Consultation Response from KC, Ecology Unit
2023/91441 31, Chapel Hill, Linthwaite, Huddersfield, HD7 5NJ
Change of use and alterations to former church (B8-storage) to 9 residential units (C3) and formation of car park (Listed Building within a Conservation Area)
Date Responded: 05/10/2023 Responding Officer: Gareth Hey Responding Ref:

Following on from my previous comments, an updated bat survey report has been submitted with the application.

PROPOSED SOUTH ELEVATION 1:100

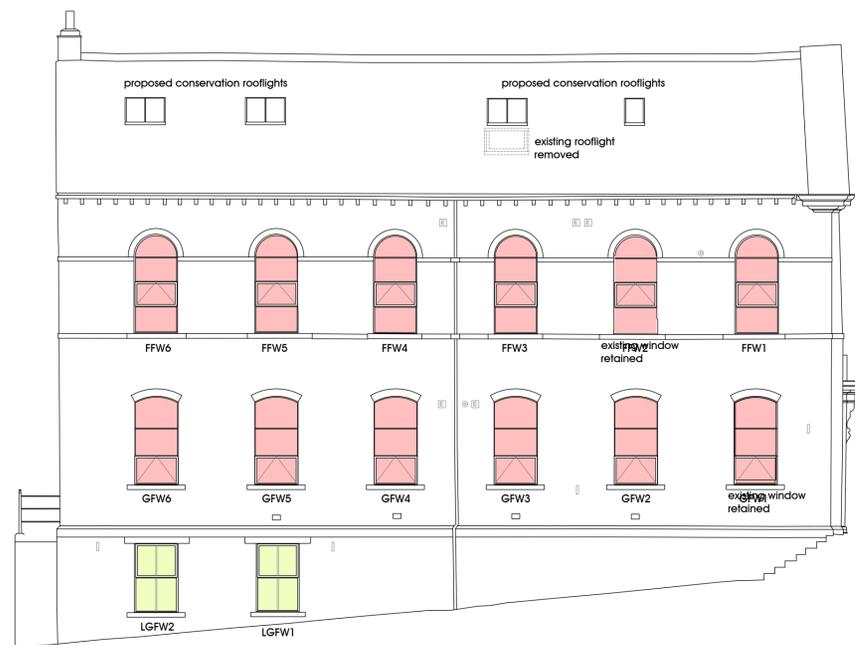
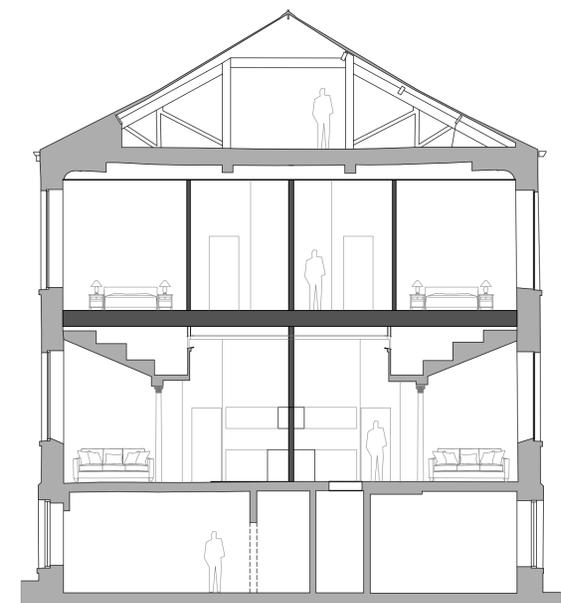
- Inclusion of at least three Schwegler 1FTH summer roosting boxes to the south elevation of the chapel and placed high up at the eaves. These can be added before roofing scaffold is dismantled.
- At least one Schwegler bat winter roost 1WQ should be added to the north elevation high up at the eaves. This will provide insulated winter roosting opportunities for bats.

1. Prior to the commencement of development, a plan detailing the positioning, location and specification of four bat roosting features (including three summer roosting boxes and one winter roost box) on or integral to the south and north elevation shall be submitted to and approved in writing to the local authority. The bat boxes shall be installed to the manufacturers specification and retained thereafter as detailed in the approved plans.
